From: Sue Howell
Sent: 04 September 2017 14:25
To: Planning.Responses
Cc: Anita Gardner
Subject: RE: Planning Consultation on LU/211/17/DOC

Comment from Greenspace

APPLICATION LU/211/17/DOC
NO:

Registered: 23-JUN-17
Site Address: 6 & 7 Courtwick Park Cottages Courtwick Lane
Littlehampton BN17 7PD

1120 / 01

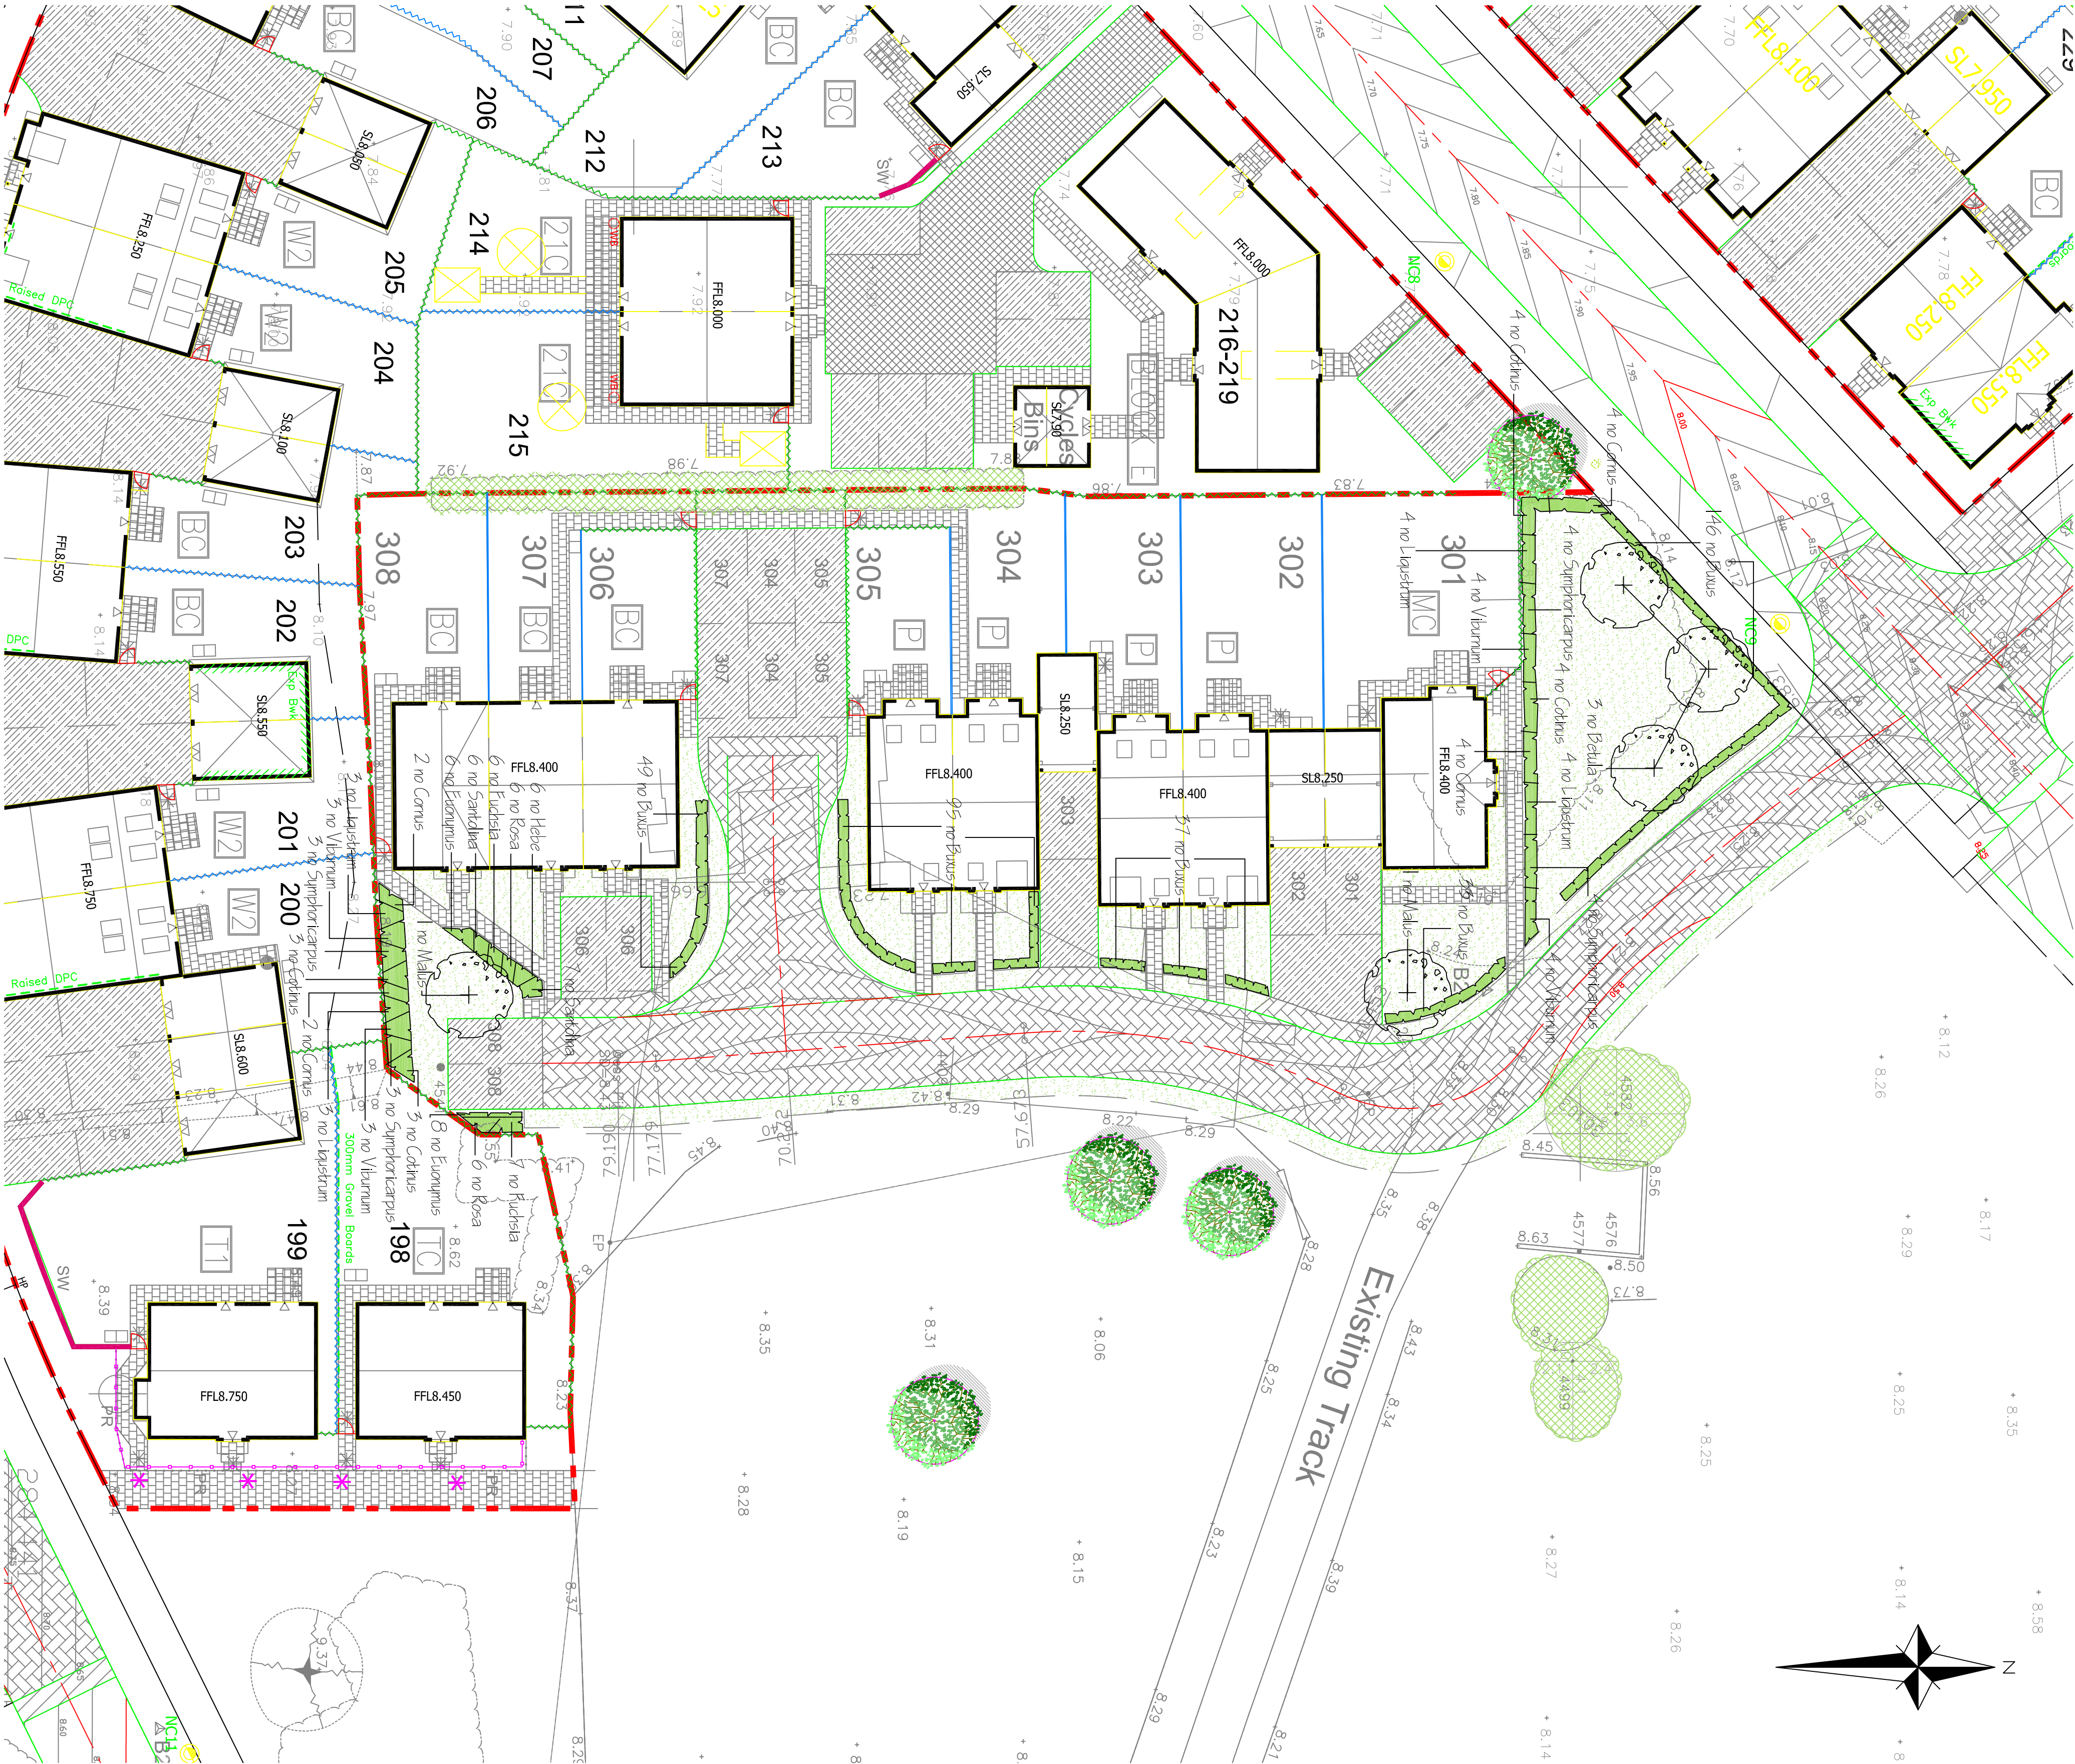
Drawings submitted under application LU/211/17/DOC Dwg 1120/01 March 2017 provide a well thought out scheme which is suitable for location with good detail of species choice in plan form being proposed, however these drawings need to detail actual numbers being proposed for each species in these locations rather than just stating a block mix of dwarf shrub and screen mix. We would **request that this information is submitted for approval** therefore we would **not recommend the discharge of Condition 4 landscaping** on application LU/211/17/DOC imposed under U/24/17/PL until this additional information is submitted and approved.
